EAST PARK ENERGY

Schedule of Changes to the Draft Development Consent Order

Document Reference: EN010141/DR/8.2

Version P06

-  Order Limits
-  Land Excluded from Order Limits

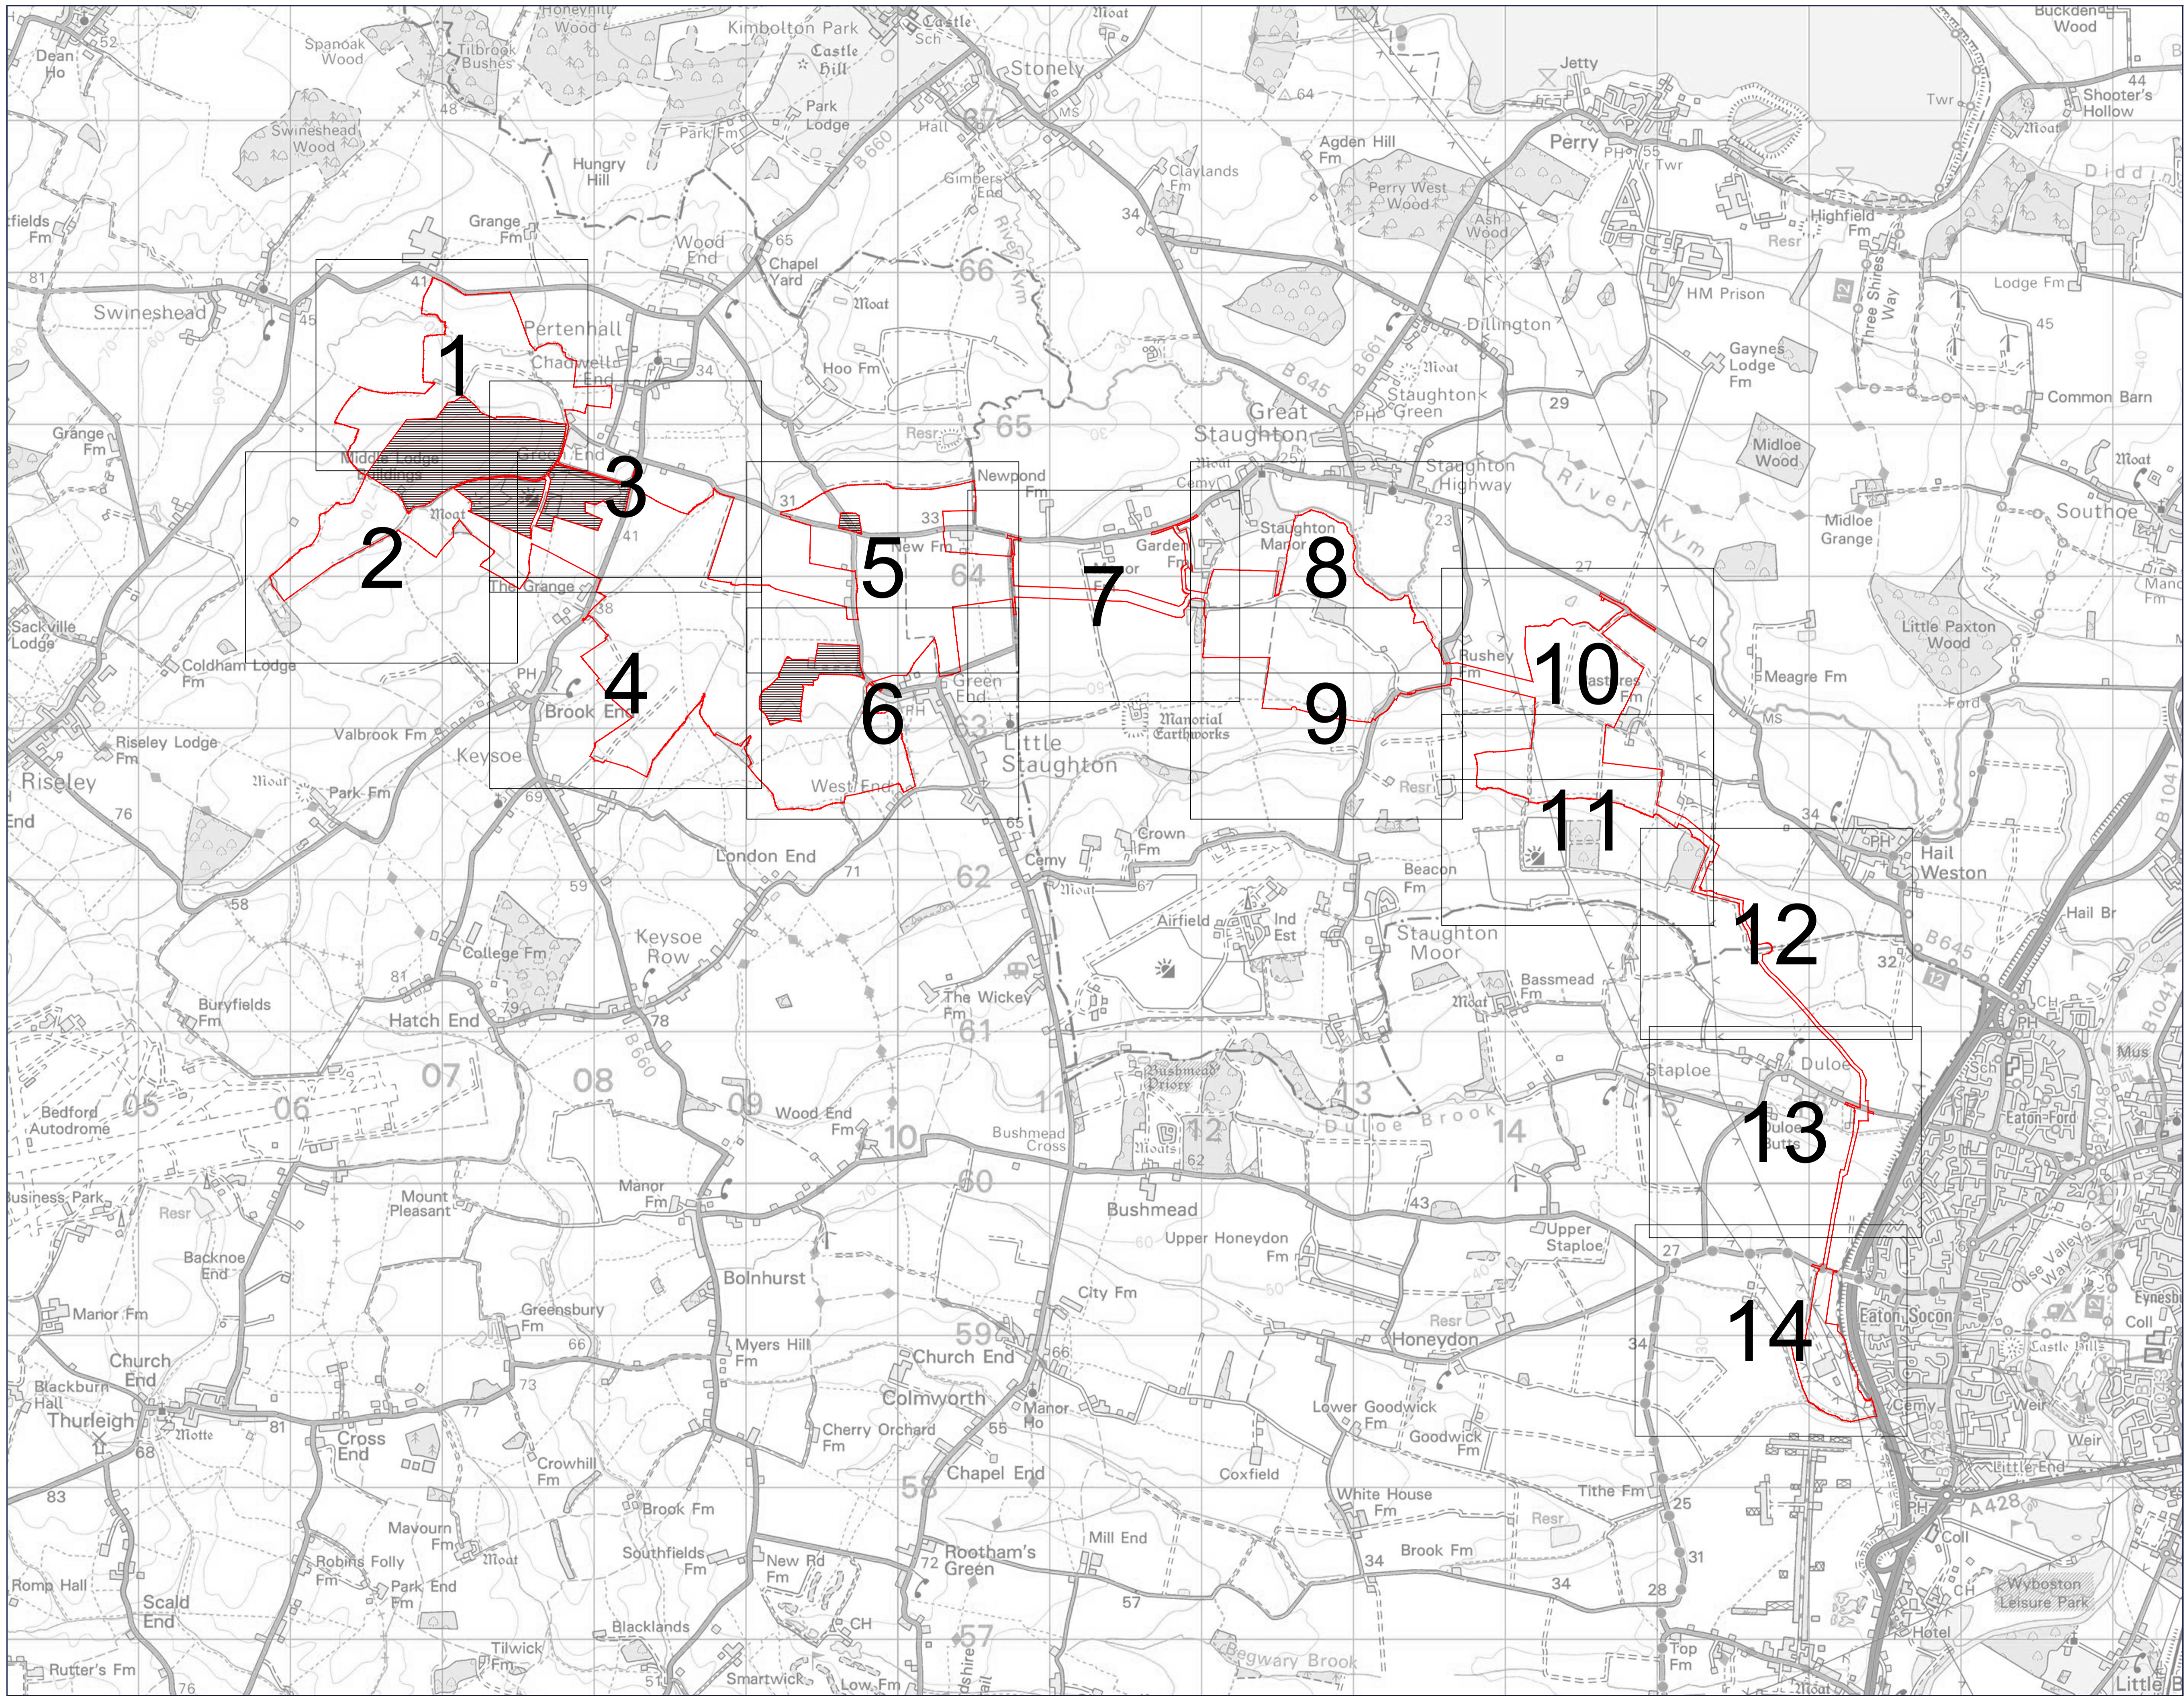
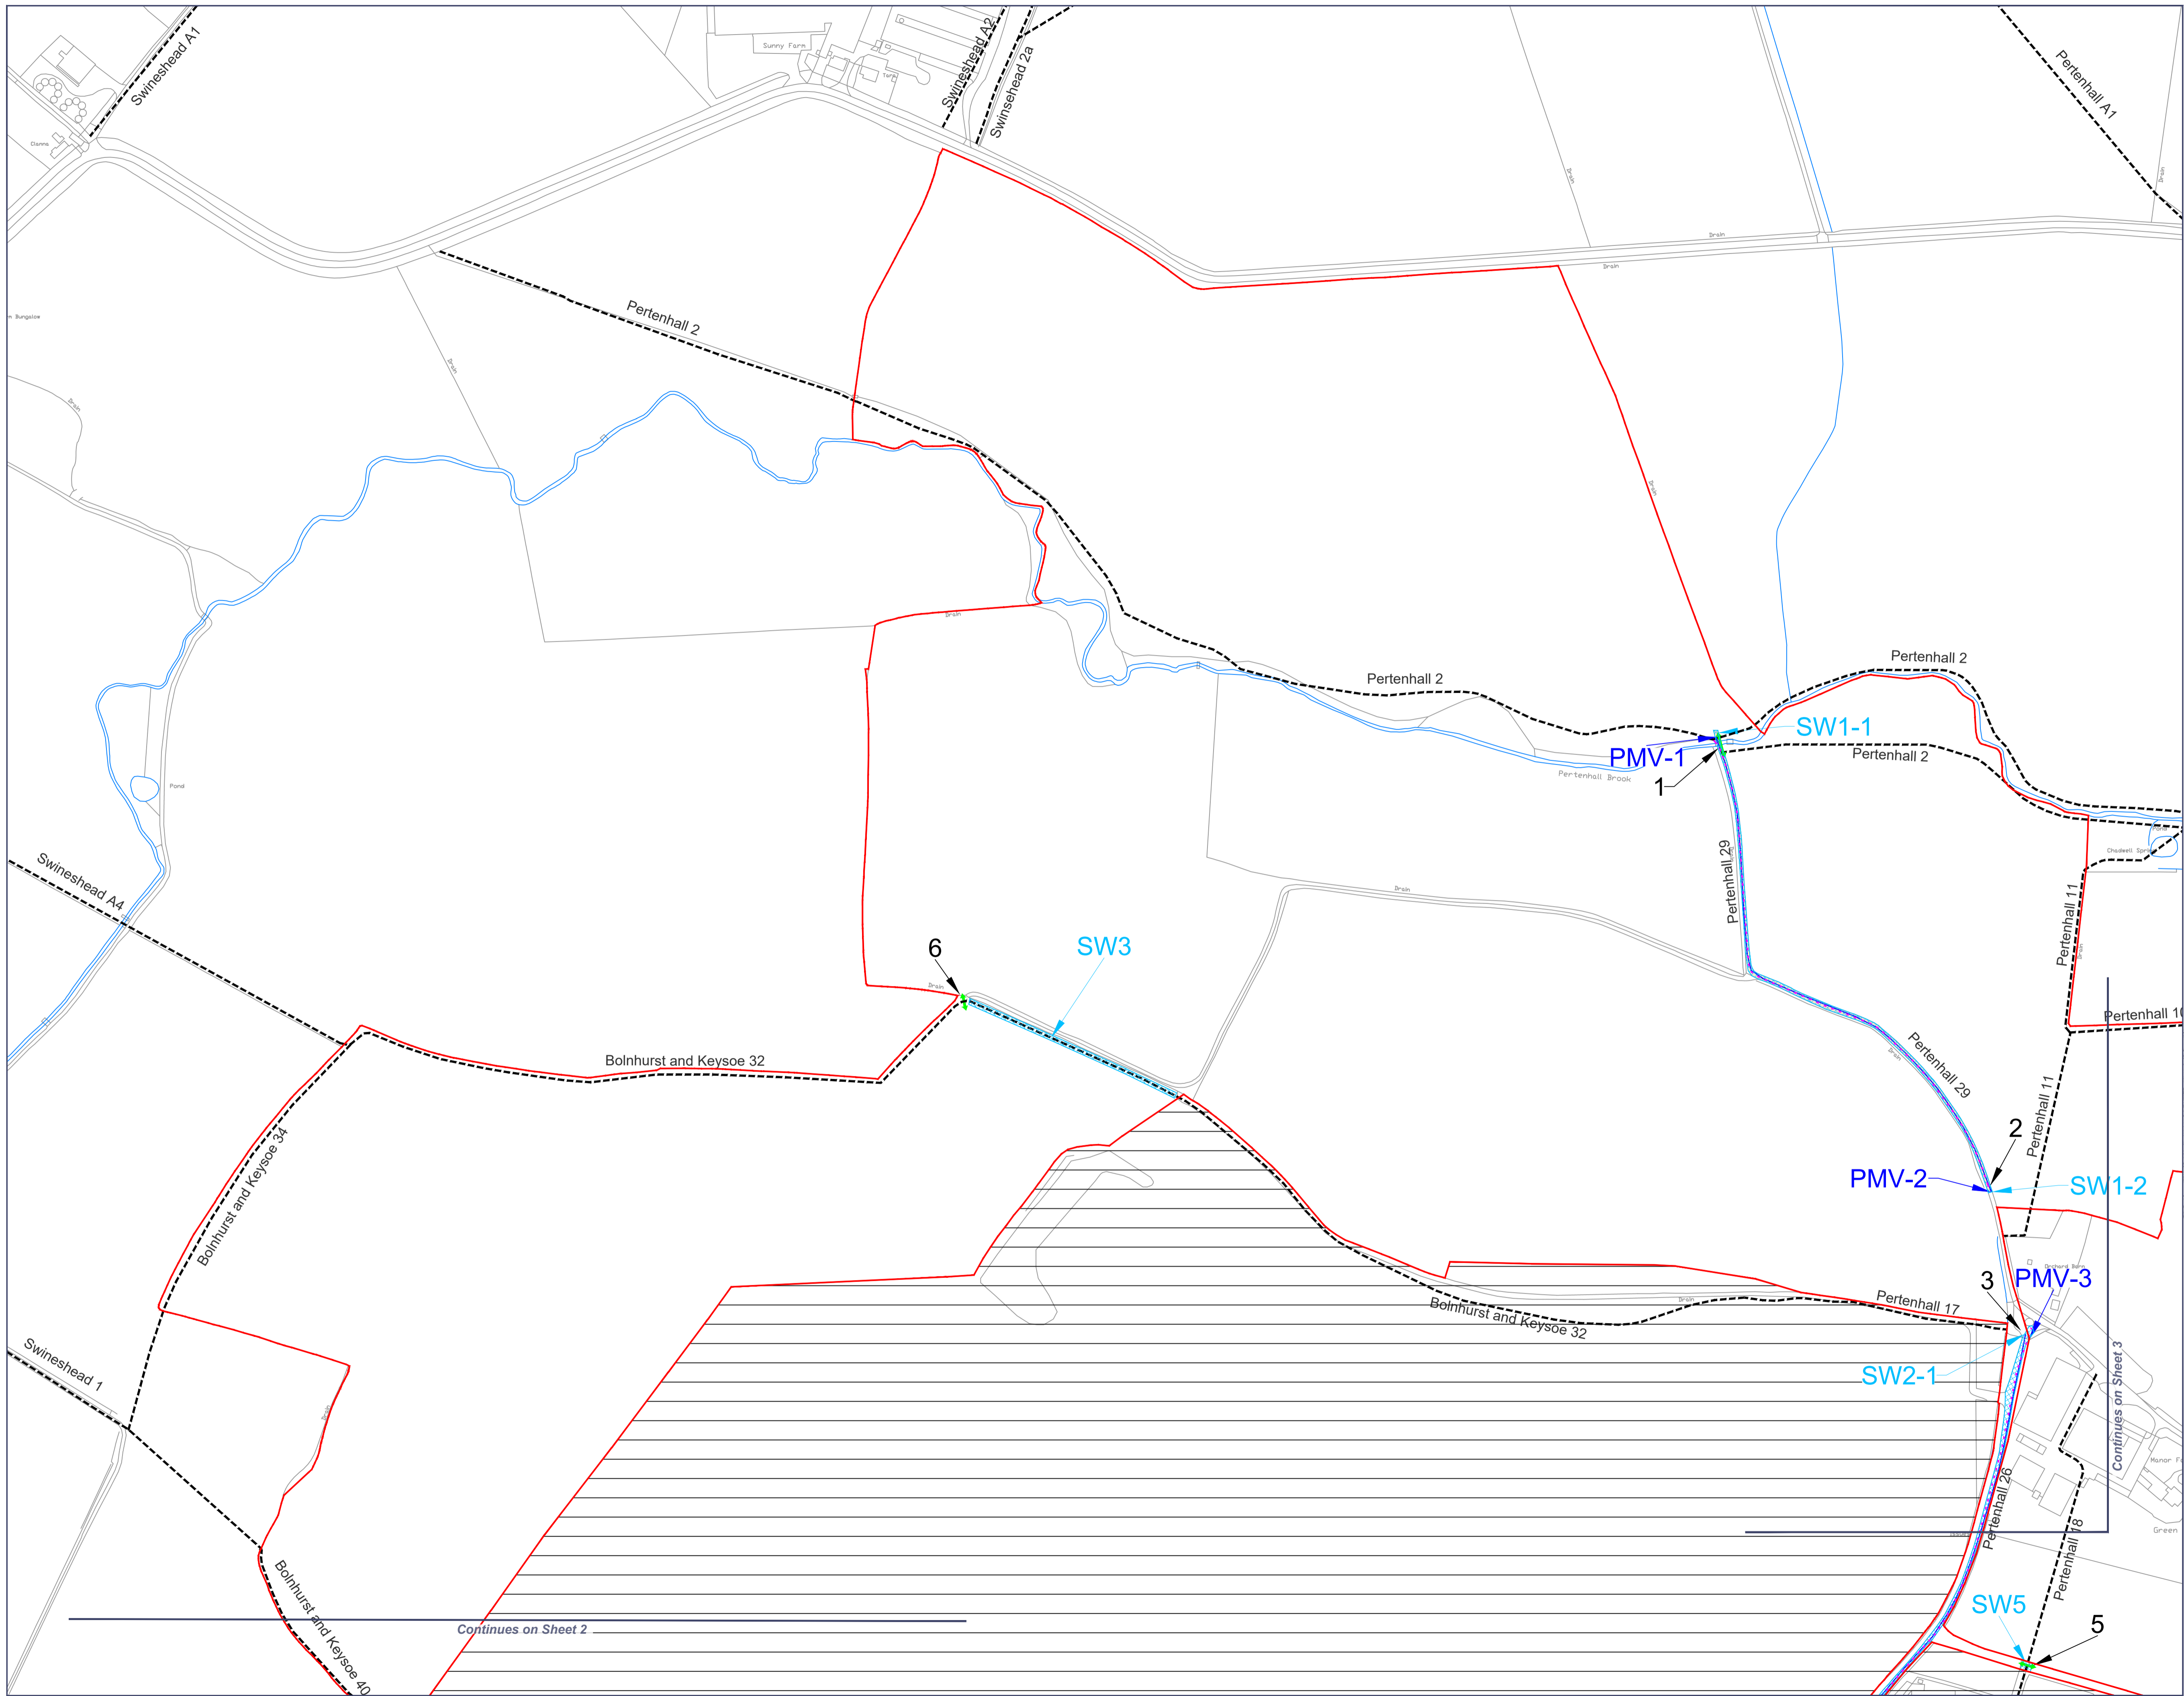
Article / Paragraph / Schedule	Amendment	Reason			
		traffic management plan in accordance with National Highways' relevant representation [RR-904] .			
Schedule 4, Streets subject to street works	A new column (4) has been added listing the relevant highway authority / authorities in relation to each of the streets referenced in the Schedule.	This amendment has been made at the request of Cambridgeshire County Council in their relevant representation [RR-150] .			
Schedule 6, Part 1, Temporary alteration, prohibition, diversion or restriction of the use of streets and public rights of way	Column (2) of the table has been amended as follows: <table border="1"> <tr> <td><i>Pertenhall</i></td><td><i>Public Right of Way – Pertenhall 29 Bridleway Footpath</i></td><td><i>Temporary management including temporary stopping up over the public right of way comprising a length of 455m between the point marked 1 on sheet 1, and the point marked 2 on sheets 1 and 3 of the streets, public rights of way and access plans.</i></td></tr> </table> "Public Right of Way – Pertenhall 29 Bridleway Footpath"	<i>Pertenhall</i>	<i>Public Right of Way – Pertenhall 29 Bridleway Footpath</i>	<i>Temporary management including temporary stopping up over the public right of way comprising a length of 455m between the point marked 1 on sheet 1, and the point marked 2 on sheets 1 and 3 of the streets, public rights of way and access plans.</i>	Correction of typographic error.

<i>Pertenhall</i>	<i>Public Right of Way – Pertenhall 29 Bridleway Footpath</i>	<i>Temporary management including temporary stopping up over the public right of way comprising a length of 455m between the point marked 1 on sheet 1, and the point marked 2 on sheets 1 and 3 of the streets, public rights of way and access plans.</i>			
Schedule 6, Part 2, Authorising permanent use of	A new row has been added to the table as follows: <table border="1"> <tr> <td><i>Pertenhall</i></td><td><i>Public Right of Way – Pertenhall 2 Footpath</i></td><td><i>Motor vehicles authorised by the undertaker may pass along or cross the length of the public right of</i></td></tr> </table>	<i>Pertenhall</i>	<i>Public Right of Way – Pertenhall 2 Footpath</i>	<i>Motor vehicles authorised by the undertaker may pass along or cross the length of the public right of</i>	This public right of way was incorrectly omitted from the draft

Article / Paragraph / Schedule	Amendment			Reason
motor vehicles on public rights of way			<i>way between the point marked PMV-1 on sheet 1 and the point marked PMV-2 on sheets 1 and 3 of the streets, public rights of way and access plans shown shaded blue.</i>	Development Consent Order.
Schedule 8, Part 2, Temporary Suspension of Weight Restriction	Part 2 of Schedule 8 has been deleted in its entirety. This means that what was Part 3 of Schedule 2 is now Part 2.			This Schedule has been removed as the temporary suspension of the weight restriction is no longer required. Please see comments above in relation to Article 17 (traffic regulation measures).
Schedule 13, Part 3, Paragraph 18, For the protection of the drainage authorities	The definition of “specified works” at paragraph 18 has been updated as follows: ““specified work” means so much of any work or operation authorised by this Order as is in, on, under, over or within the watercourse 16 metres of a drainage work or is otherwise likely to— (a) affect any drainage work or the volumetric rate of flow of water in or flowing to or from any drainage work; (b) affect the flow, purity, or quality of water in any watercourse; or (c) affect the conservation, distribution or use of water resources.”			This amendment has been made at the request of Cambridgeshire County Council in their relevant representation [RR-150].
